From: Val Cousins [REDACTED]
Sent: 10 June 2010 08:29
To: Planning.Responses
Subject: OBJECTION: Planning Consultation on: K/12/10/

Kingston Parish Council objects to planning application k/12/10 re 28 Coastal Road Kingston because:

APPLICATION NO: K/12/10/

Description of Works: Extensions at rear to form garden room area and breakfast area & new garage at front west side. New bow window on front of former garage to be used as a dining room

S I T E P L A N
S C A L E 1 / 5 0 0

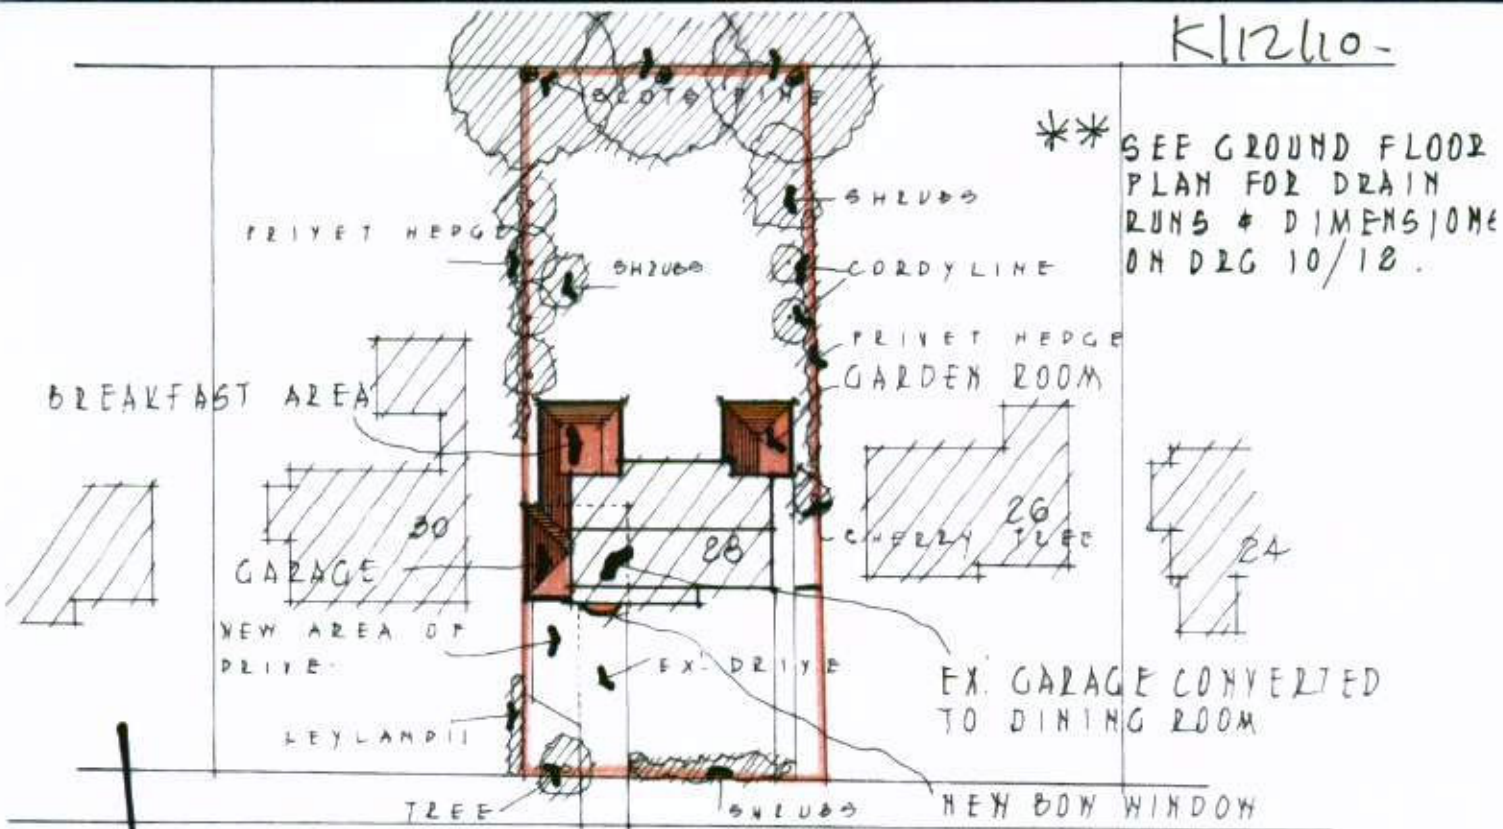
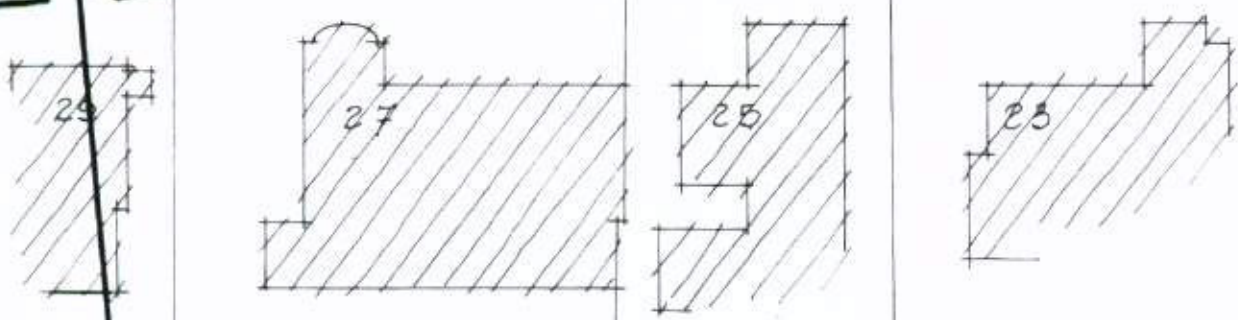
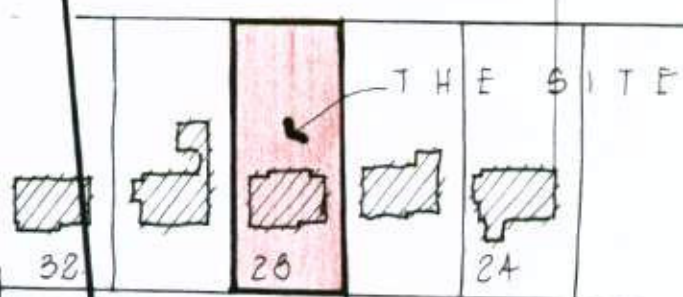
- the proposed development is too close to the boundary with the neighbouring property
- this infilling of the plot is contrary to the general provision of free standing between plots and will have a detrimental effect on the general ambience and visual open design of the neighbourhood
